## WEST SUSSEX COUNTY COUNCIL CONSULTATION

| <b>LOCATION:</b>                | Land at rear of Cedar End<br>Eastergate Lane<br>Eastergate<br>PO20 3SJ                                                                                                                                                                                                                                                                                                                  |
| <b>SUBJECT:</b>                 | BN/65/22/PL<br><br>Sever land and erection of 1 No bungalow with new vehicular access (resubmission of BN/14/22/PL). This application is a Departure from the Development Plan and is in CIL Zone 3 and is CIL Liable as new dwelling.<br><br>More information received<br><br>An amendment to the above application dated 16th August 2022 relating to:- visibility splays plan added. |

Land r/o Cedar End, Eastergate ^ Maximum Visibility Splays ^ 1:2000@A3 ^ 1671-SYM-00-ZZ-DR-A-0214 P01

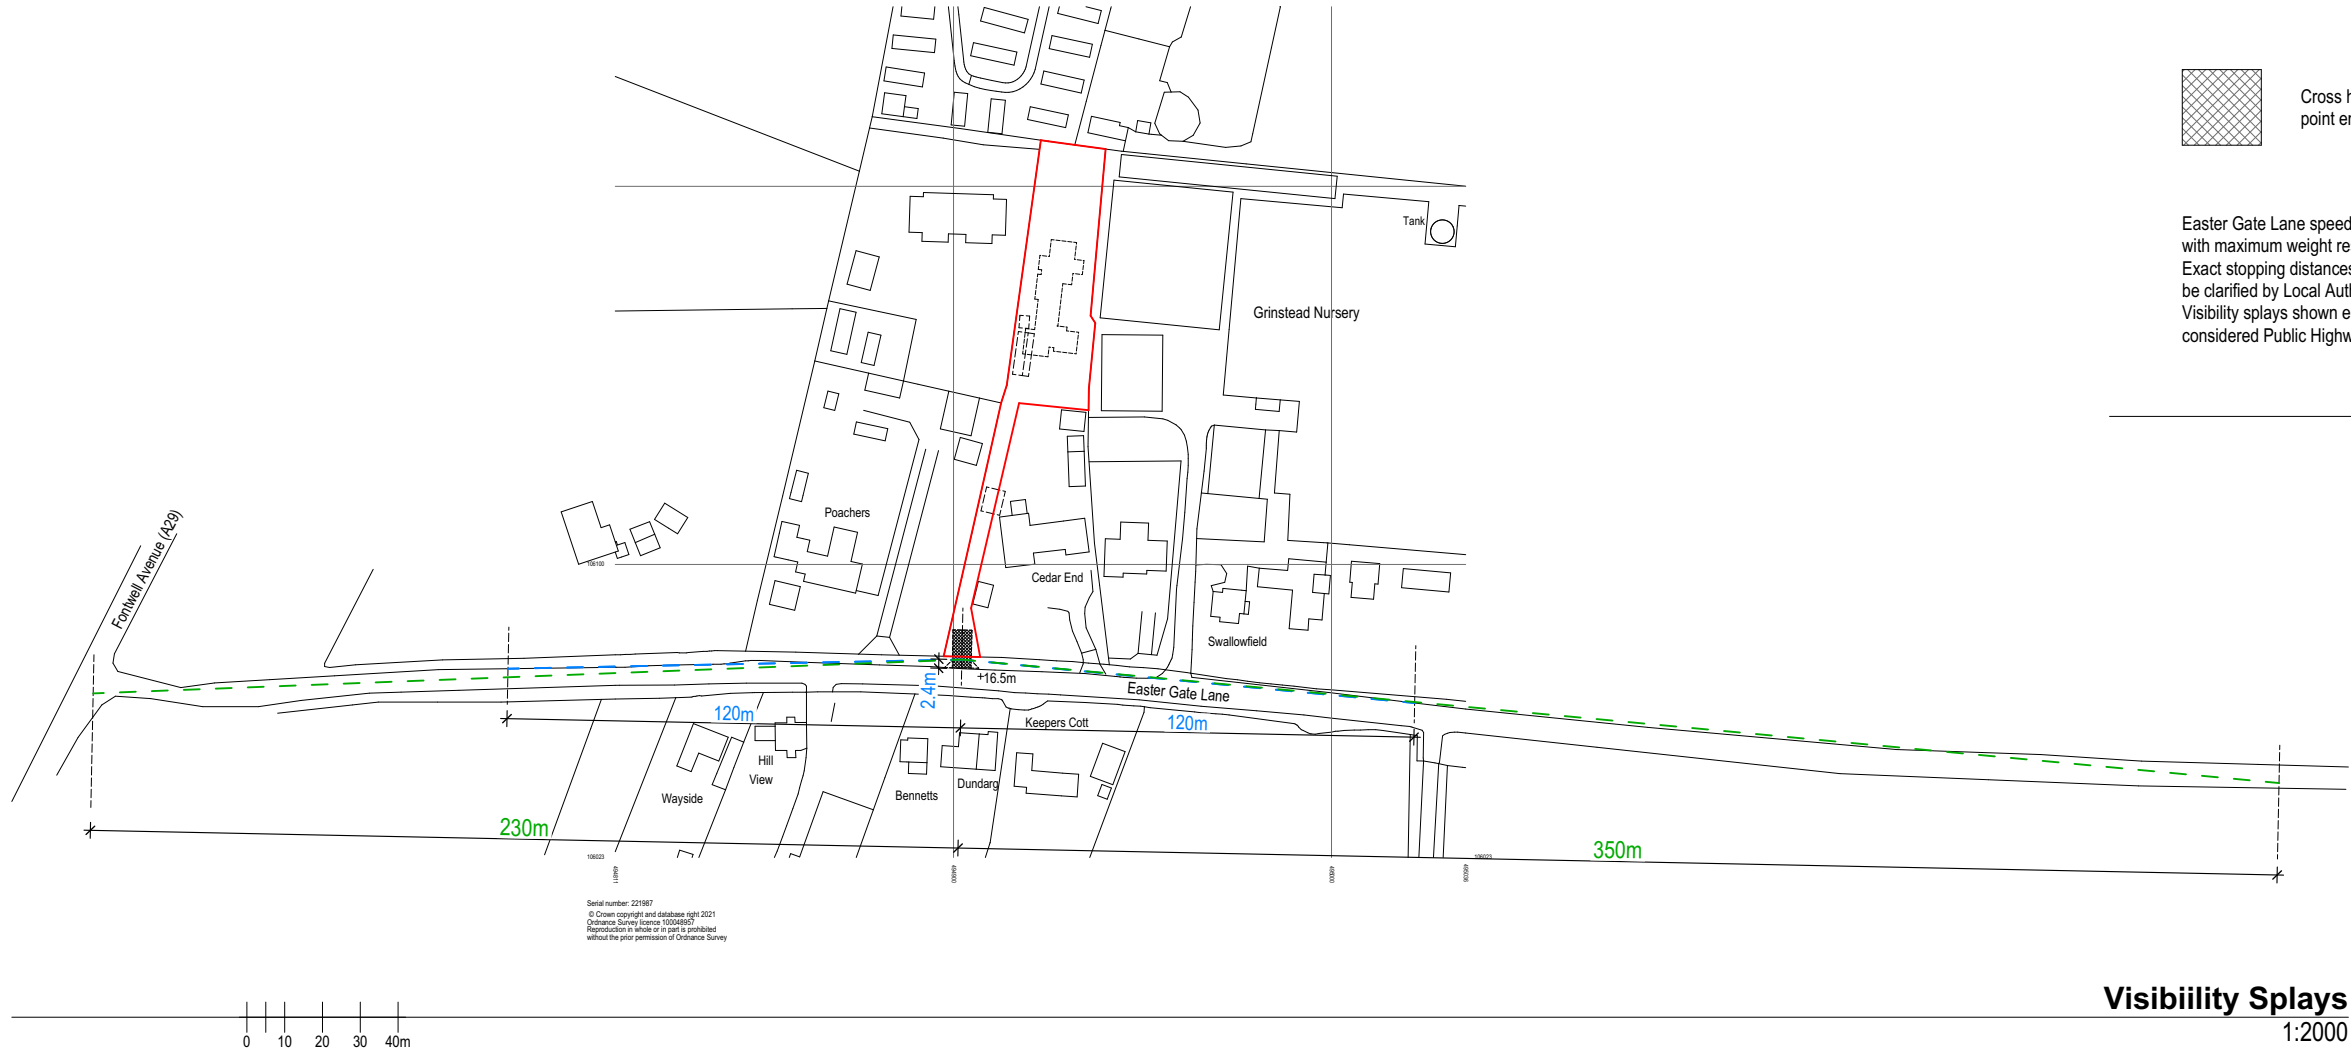
The applicant has incorrectly demonstrated maximum achievable visibility splays.

All Visibility splays must include a 2.4 metre setback distance from the kerb edge and span in both directions to the kerbed edge or edge of the adopted carriageway. The splays must not intersect third party land, be found solely within land under the control of the applicant or within the Publicly Maintained Highway and include the current carriageway geometry. We have supplied a diagram below for your guidance only.

As previous, the LHA requests a 7-day speed survey is conducted.
